OFFICIAL NOTICE OF DECISION

CITY OF ALBUQUERQUE
PLANNING DEPARTMENT
DEVELOPMENT REVIEW BOARD

3. **Project # 1002050**

03DRB-01059 Major – Preliminary Plat Approval

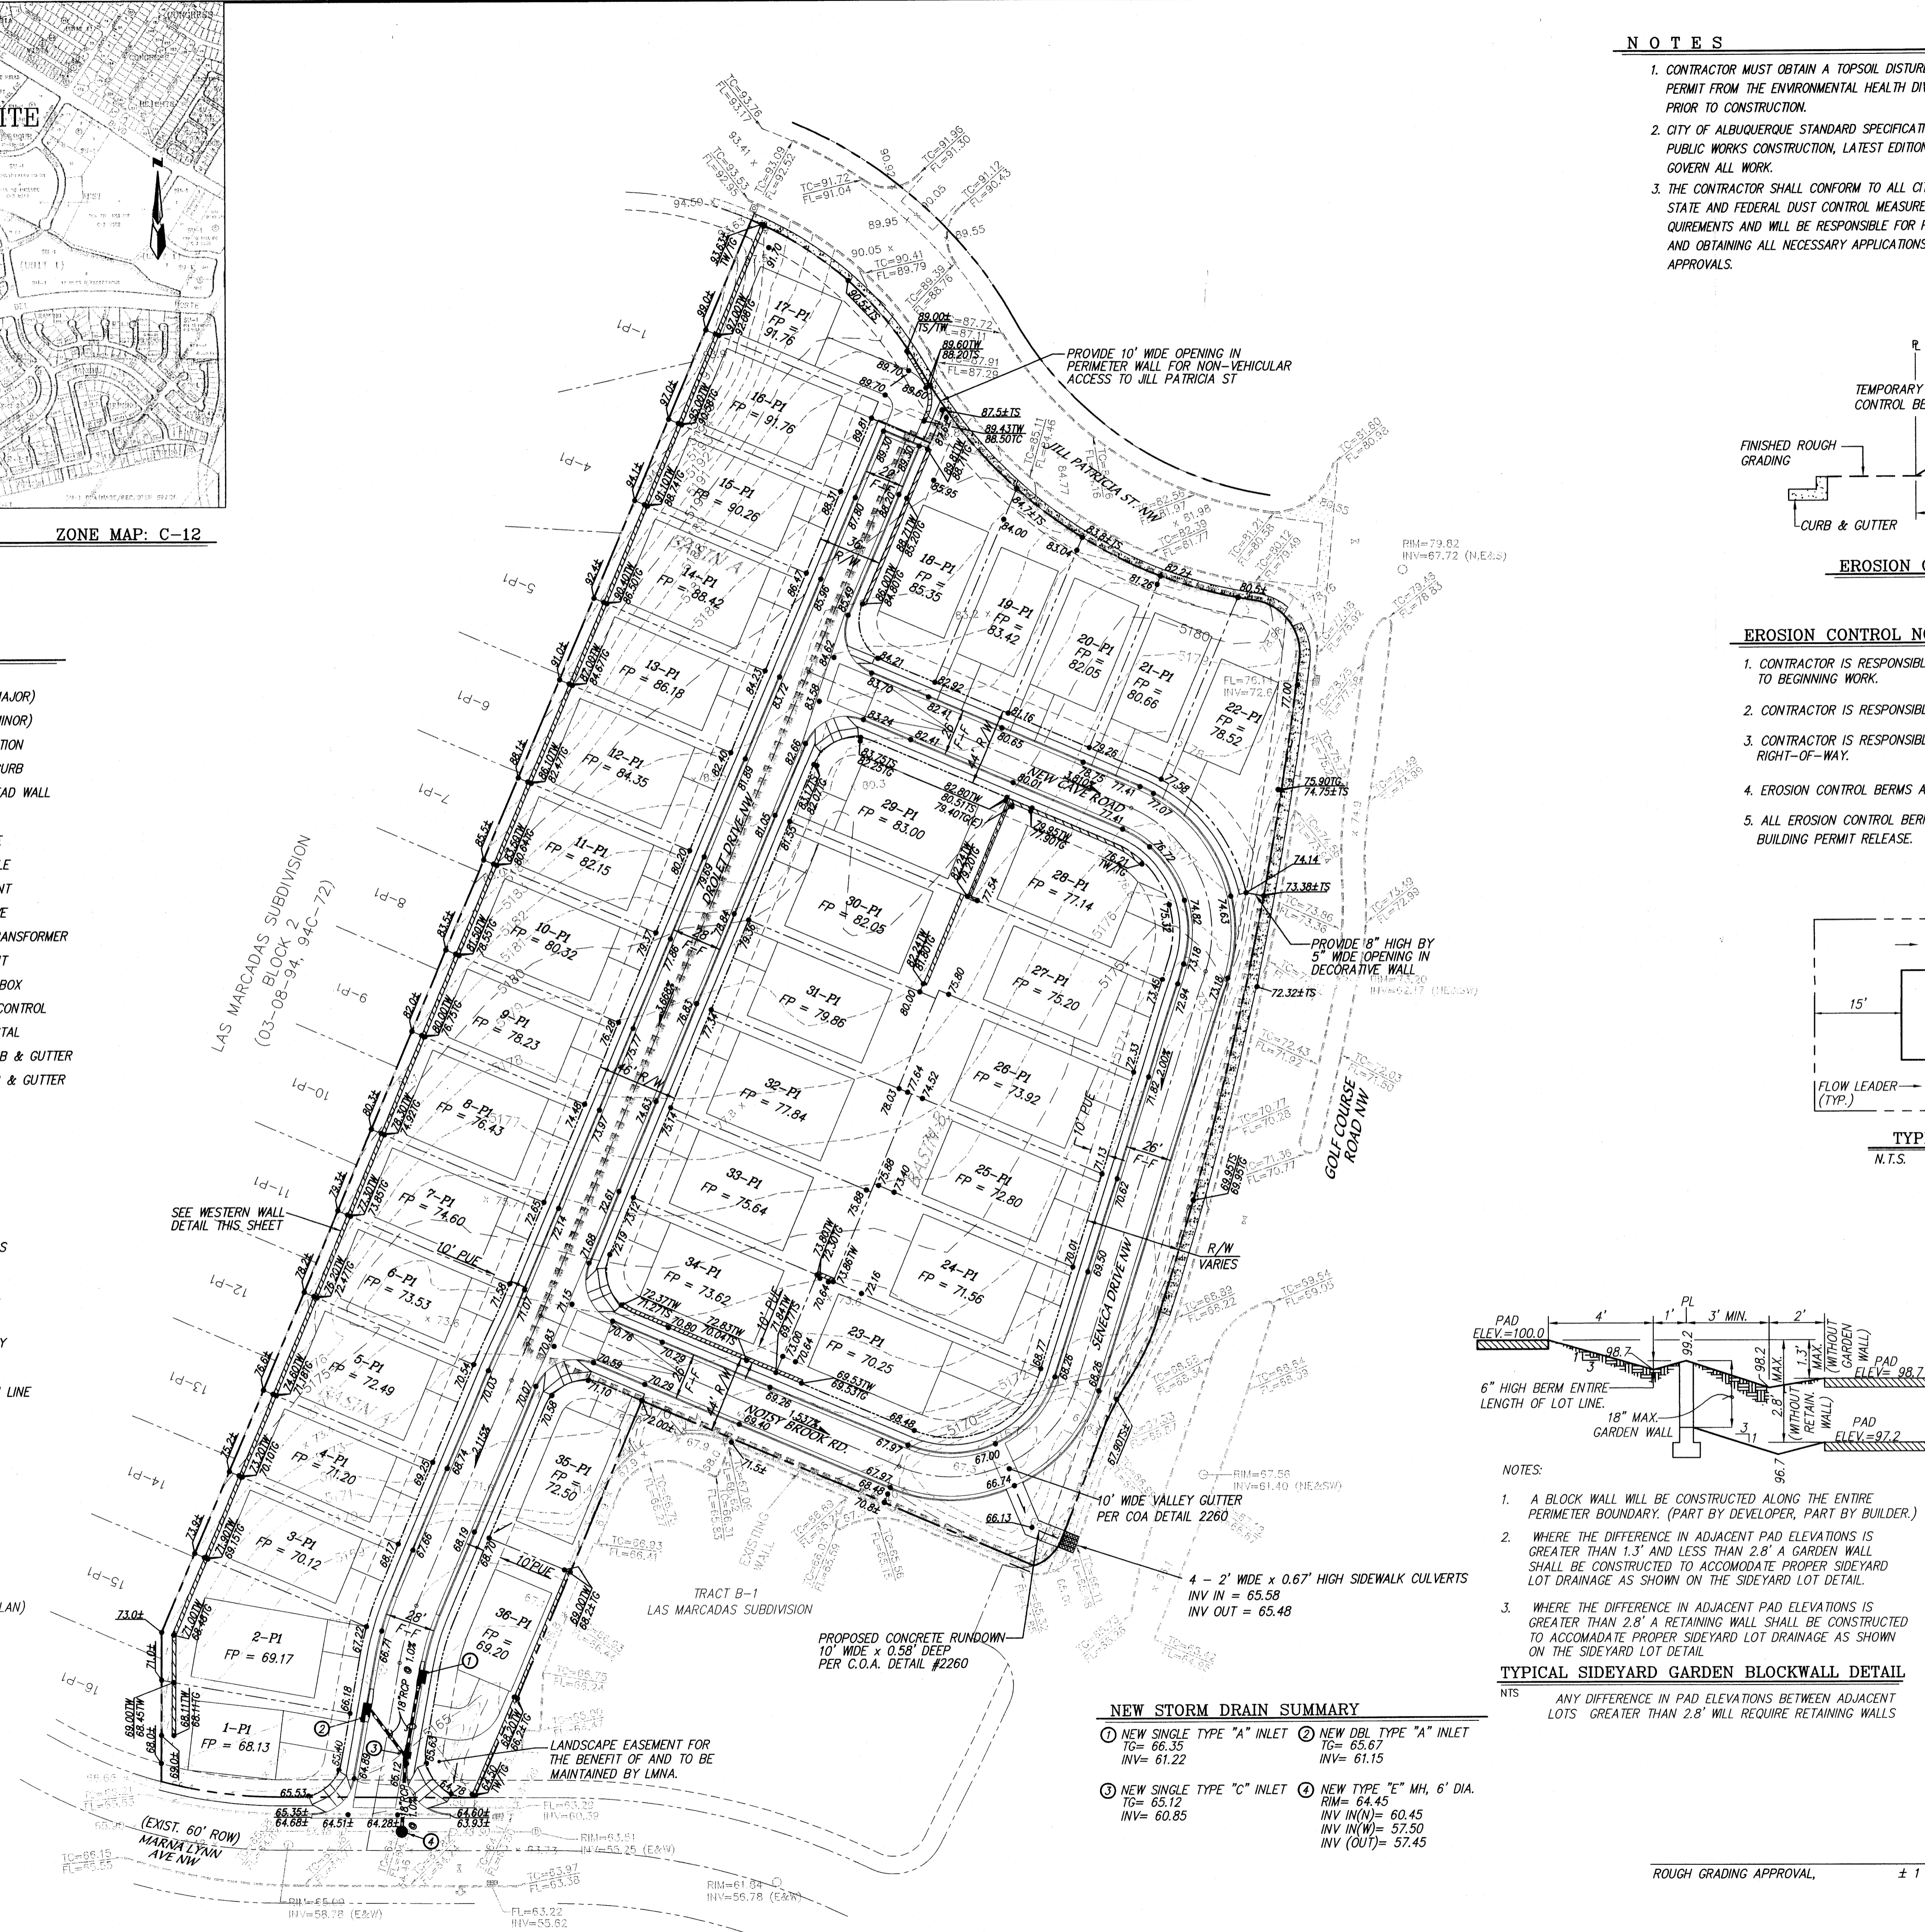
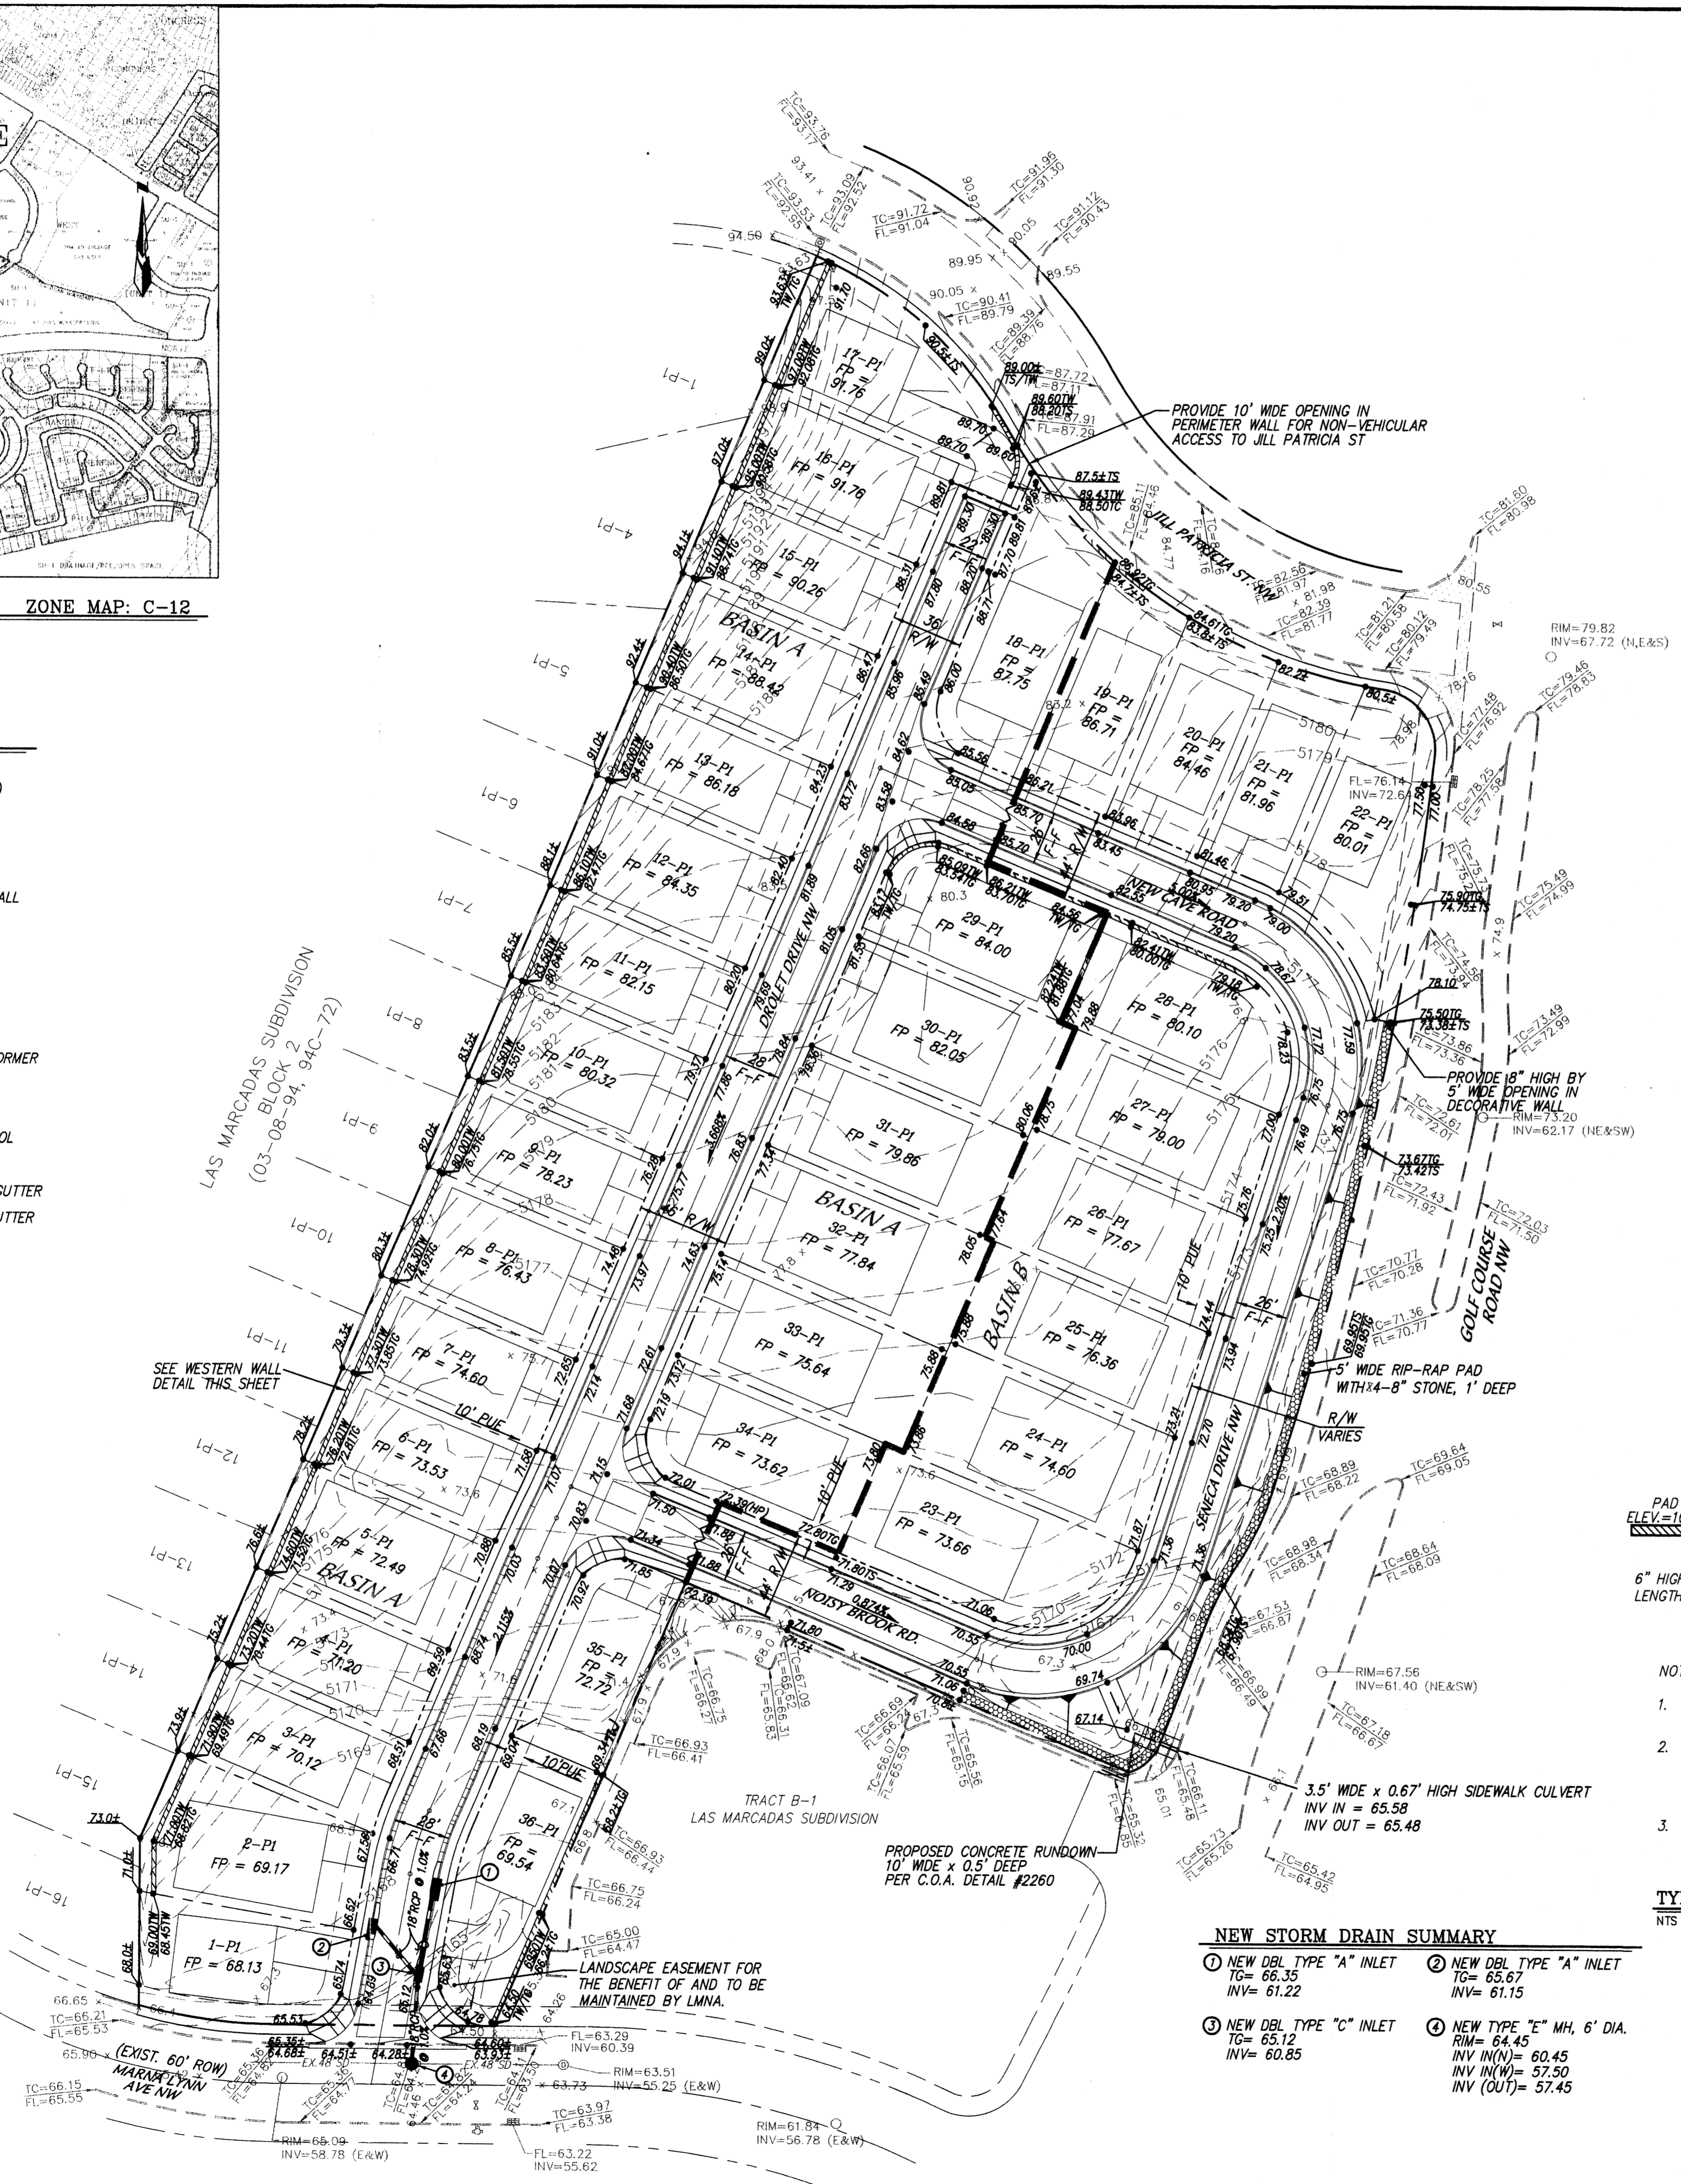
1. The grading plan shall be revised to better reflect Transportation's comments on Seneca Drive.
